**NEWCASTLE JOCKEY CLUB NEW STABLES COMPLEX (SSD-12982045) 125
CHATHAM STREET BROADMEADOW**

I refer to the Department's electronic notification of 13 October 2021 advising a State Significant Development Application (SSD-12982045) has been submitted for the construction of new horse stables and training facilities and requesting City of Newcastle (CN) to provide advice.

SITE PLAN
Scale 1:1000 @ A1

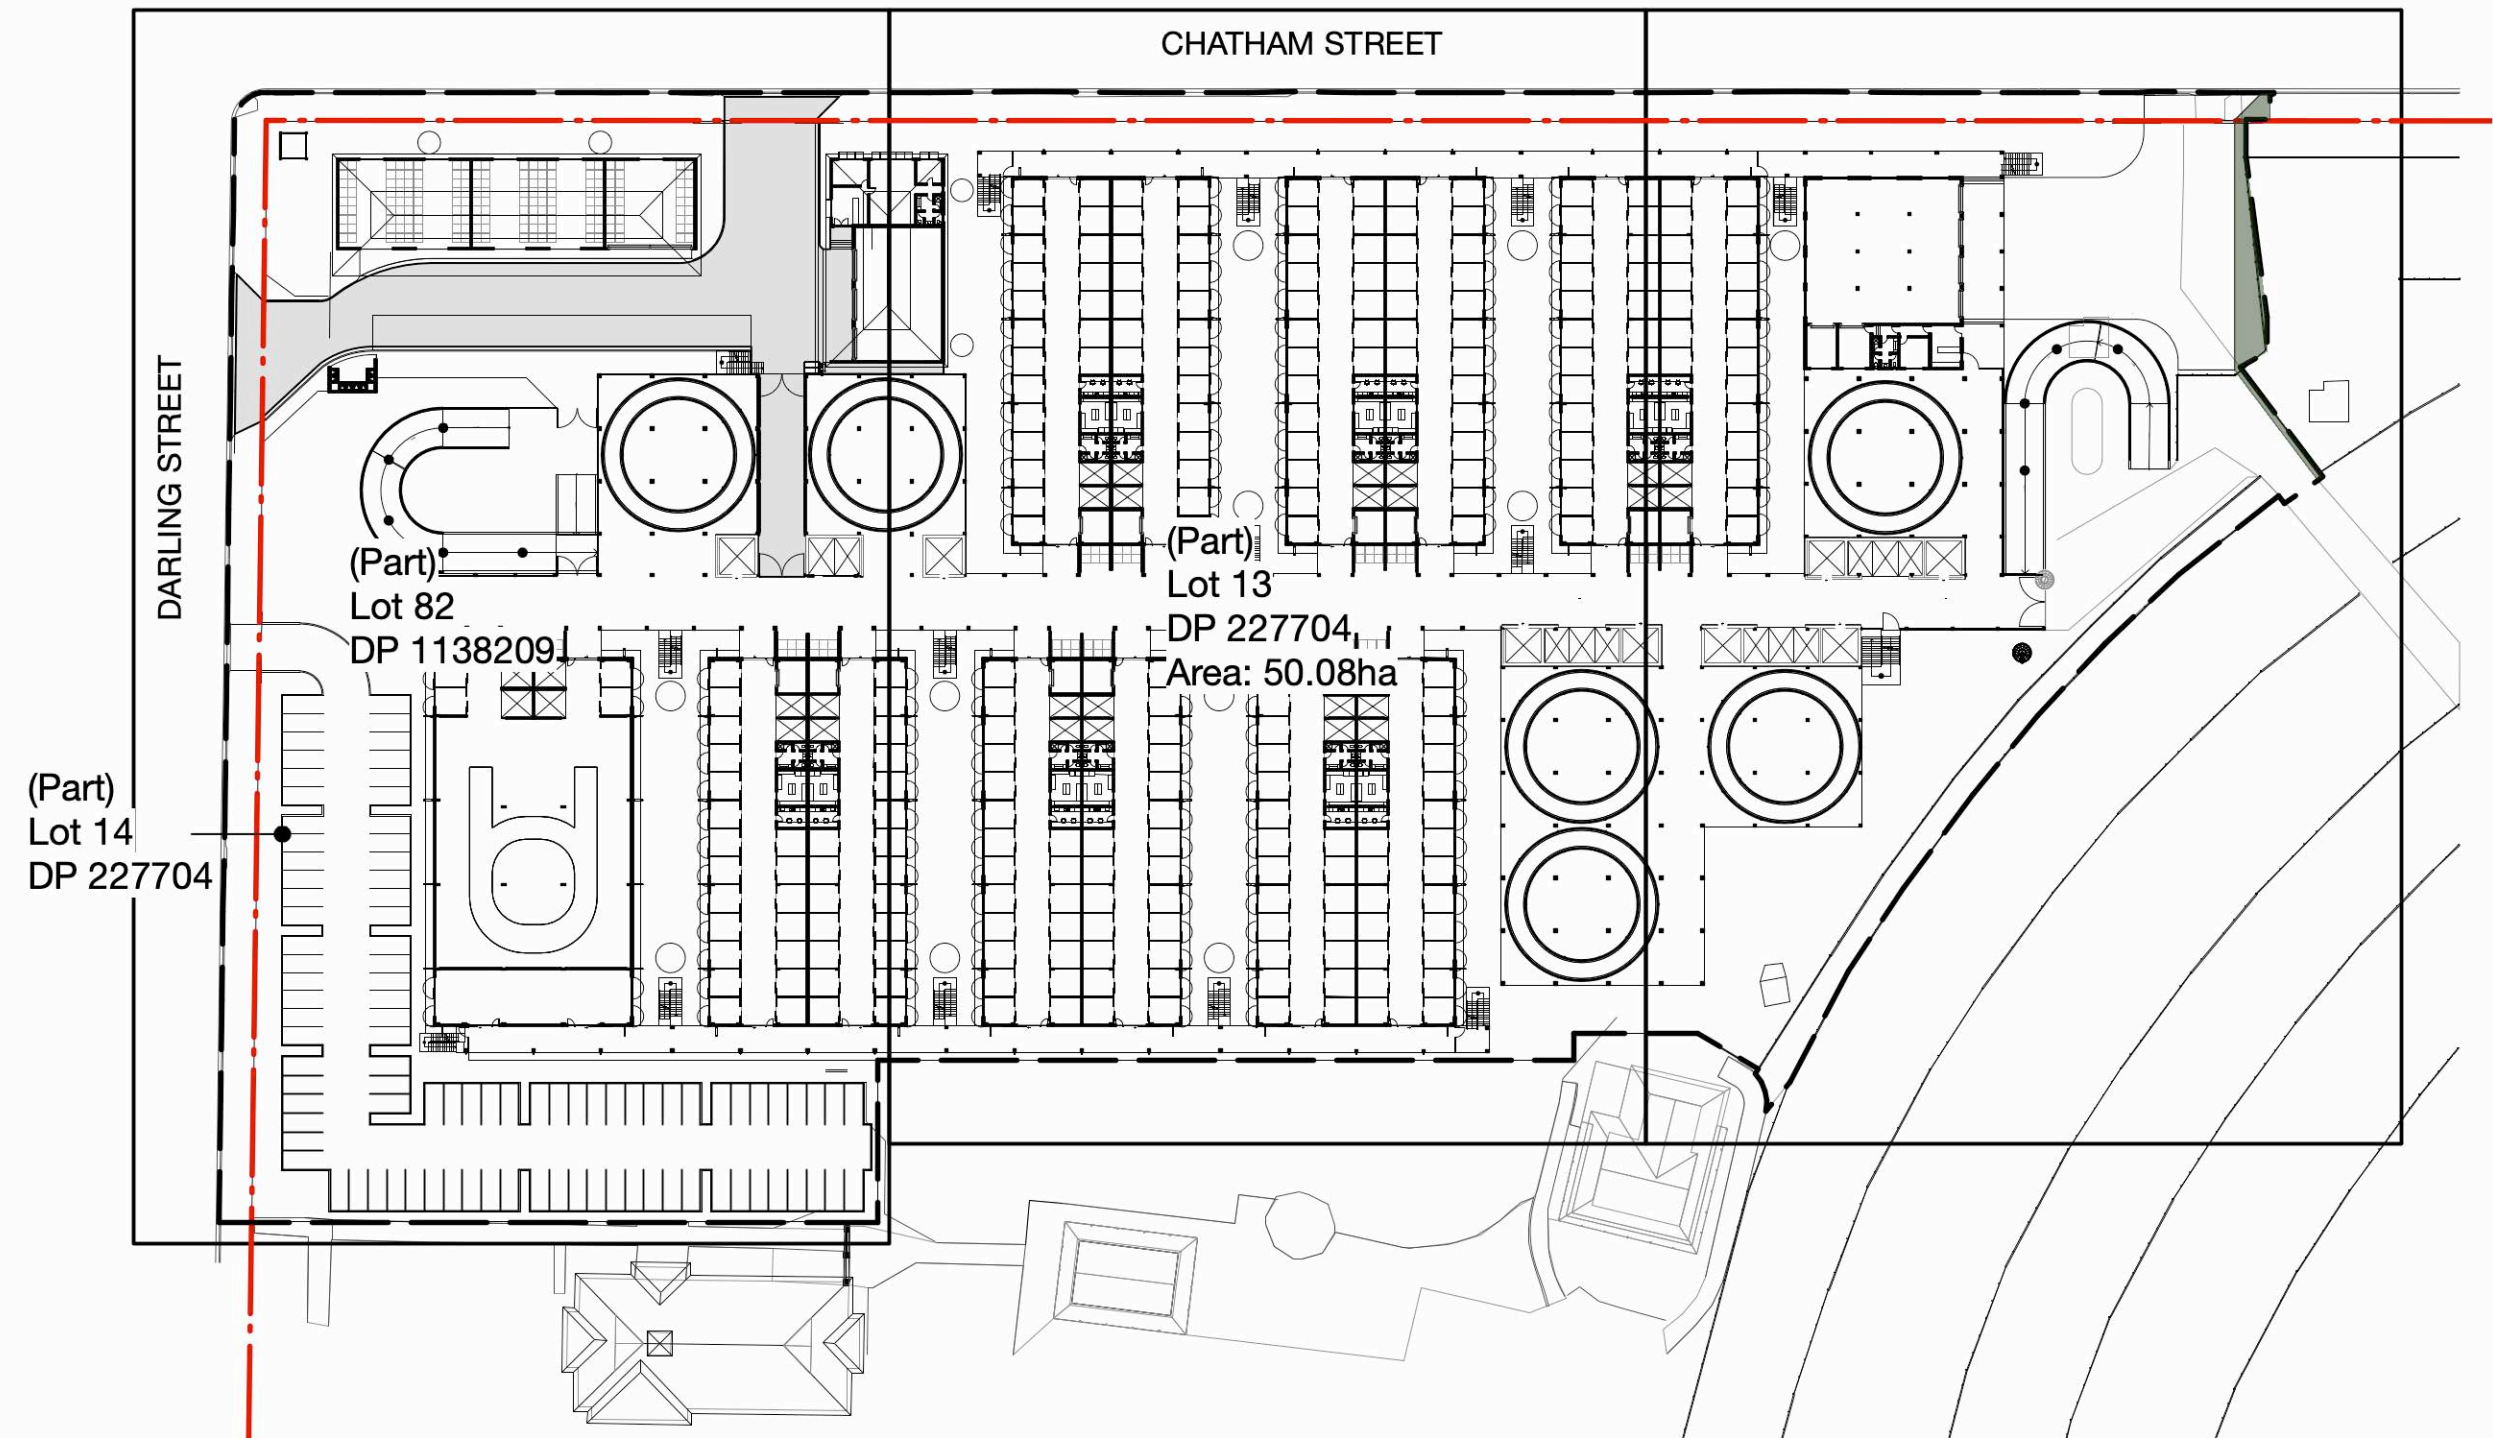
It is noted that landscaping works indicated on the architectural plans and aerial views are not consistent with that shown on the landscape plan. For example: the architectural plans show significant tree planting on site, while the landscape plan refers to tree plantings in the public domain. Furthermore, the scale and bulk of the proposed development is not shown relative to the existing residential and educational development in the locality of the site. The plans also do not indicate the proposed 2.4m high acoustic fence along the western site boundary opposite the proposed Maintenance Shed. It is recommended that the applicant is required to submit amended architectural plans and aerial views which address the above concerns.

The recommended FPL is 6.85 AHD. The FPL for the Stable Blocks A-G, the Maintenance Amenities and the Horse Walker platforms have been set at RL 7.0m which is acceptable. However, the proposed Goods Storage Shed located in the south-west corner of the site and the Equipment Shed are set at RL 6.5 which is below the recommended FPL. It is recommended that the abovementioned sheds are set at the minimum FPL of 6.85m AHD.

TURNING PATH ENTRY PLAN SHEET 1  
SCALE 1:500

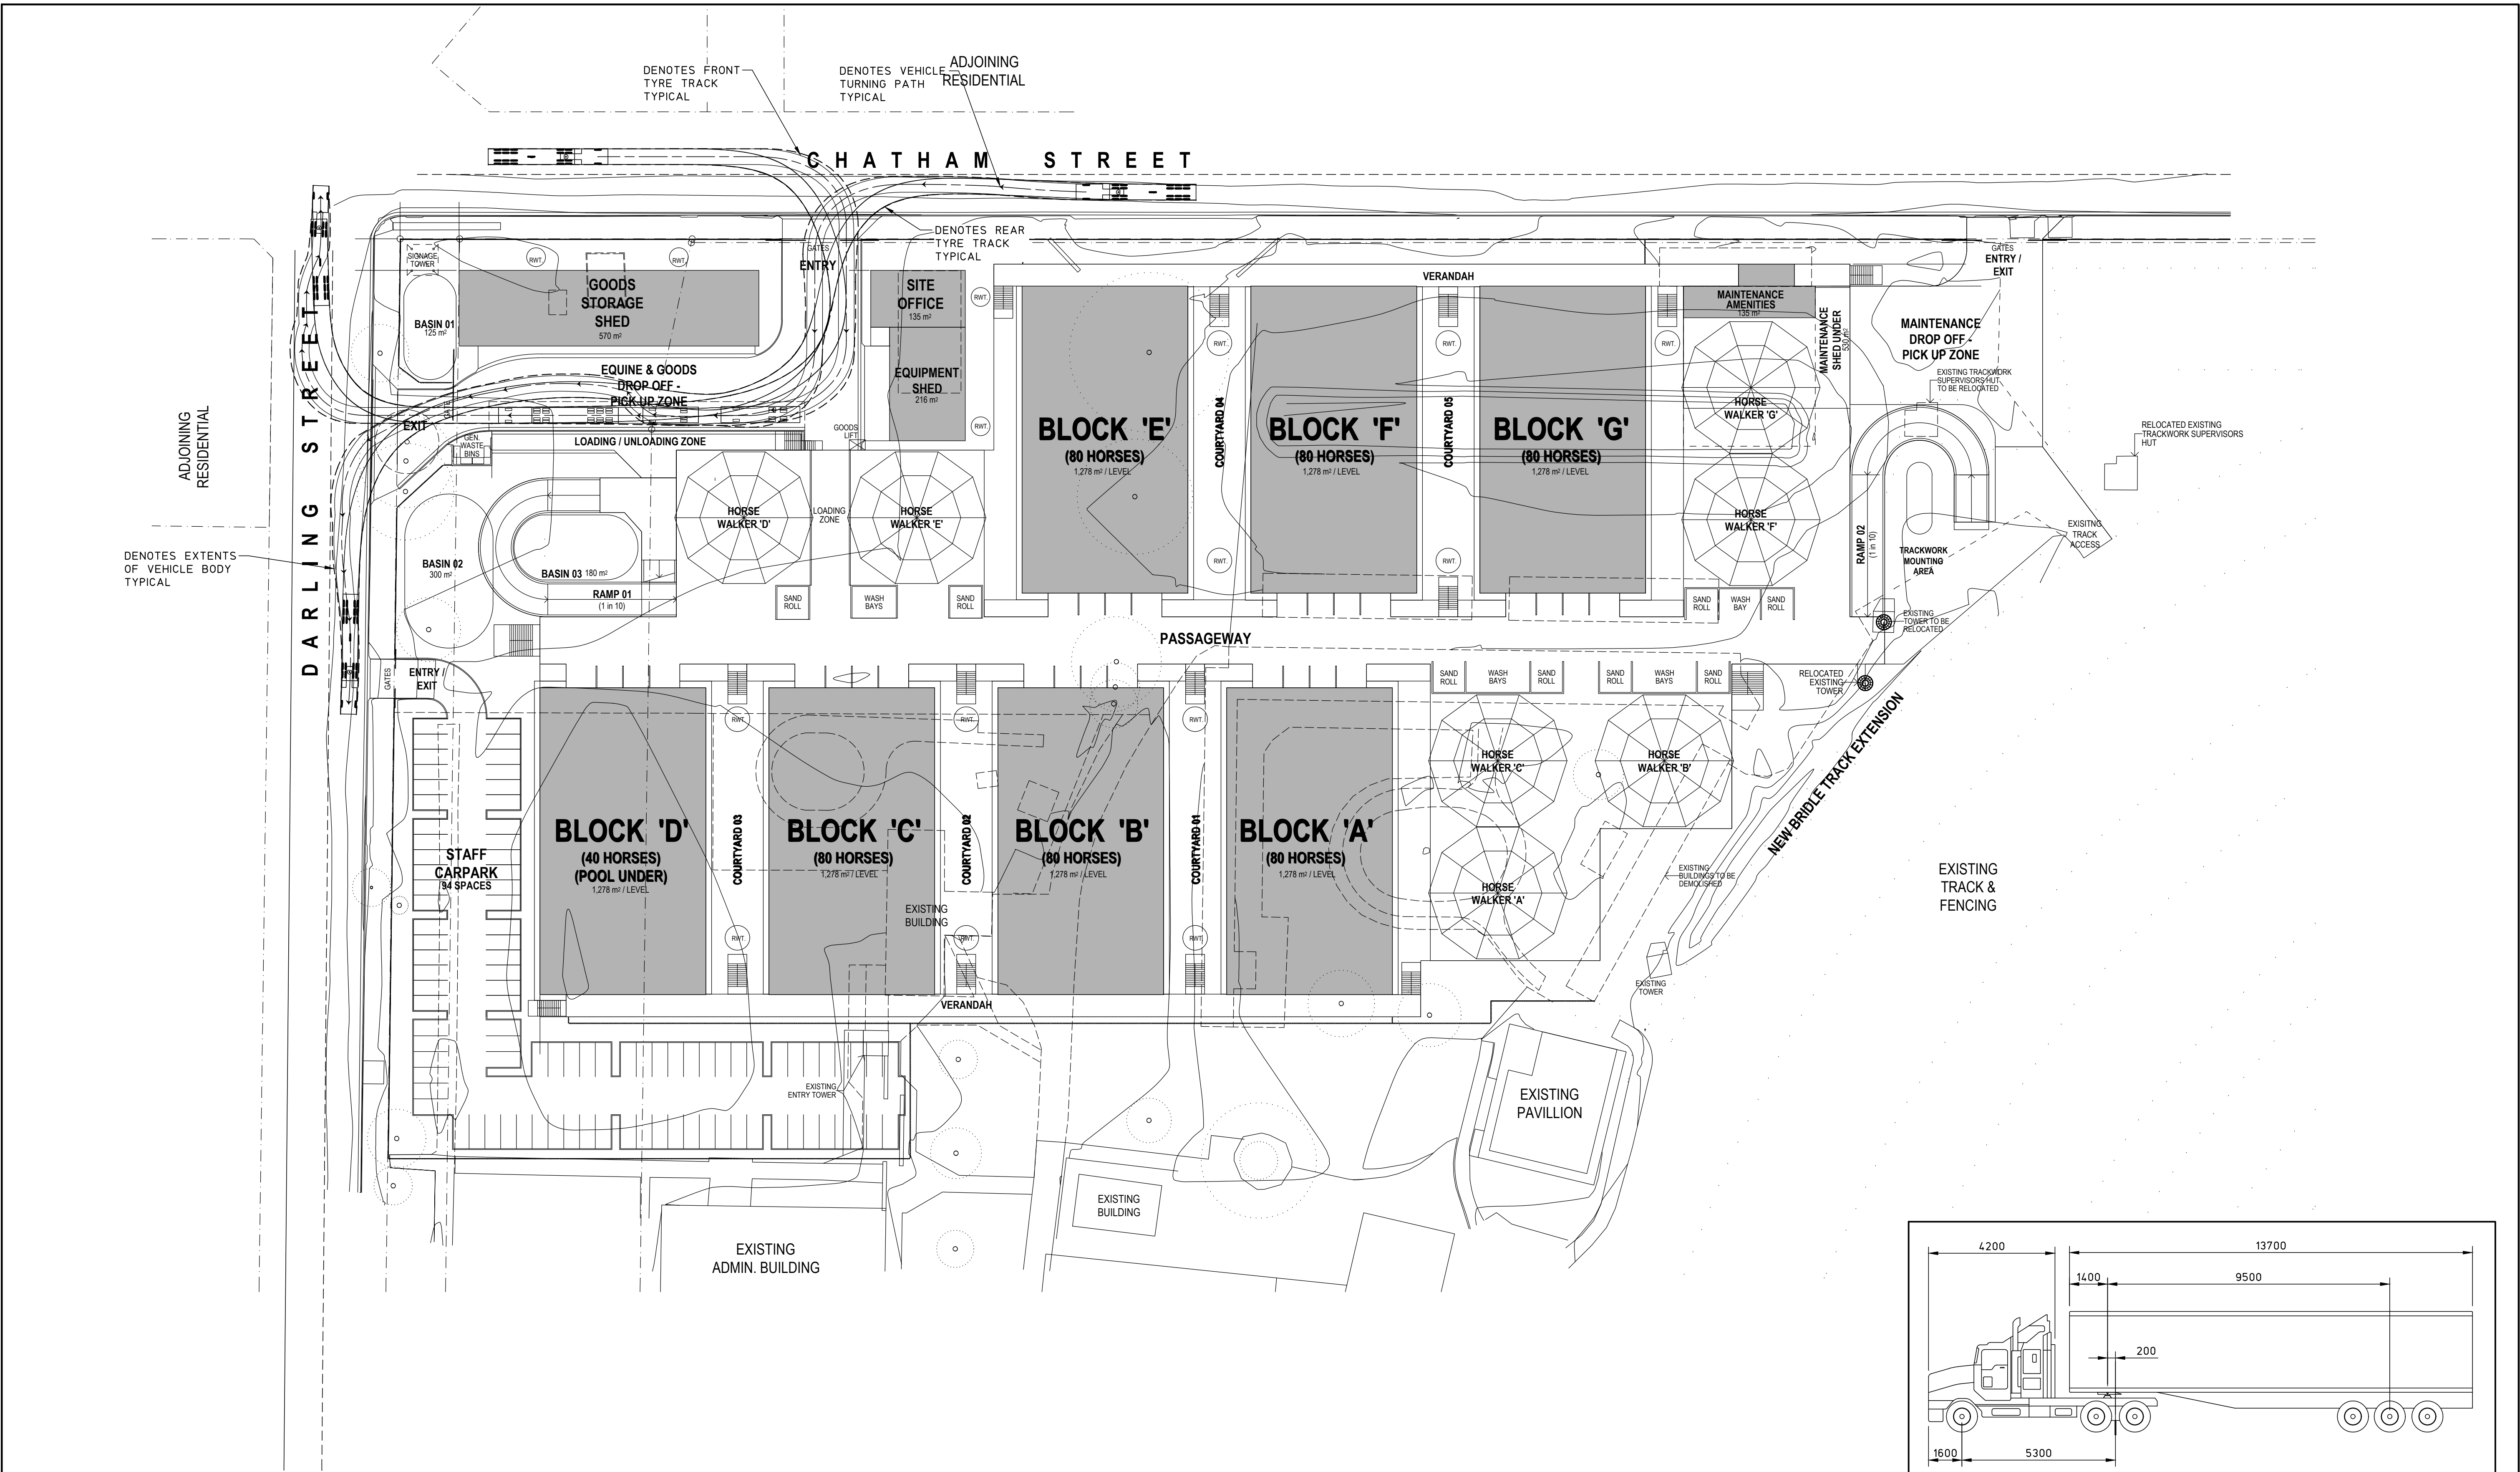
- The intersection of Chatham Street and Darling Street is already congested during race days and a roundabout as an immediate road infrastructure device is required to manage both traffic on race days and that generated by the proposed development. Traffic signals may be required as a long-term solution. The provision of these devices will impact on the design of the development, in particular the proposed Signage Tower, Basin 1 and Goods Storage Shed. At a minimum, a splay will be required on the south-west corner of the development site similar in dimensions to that on the northwest corner of the intersection. It is recommended the applicant submit amended design plans.
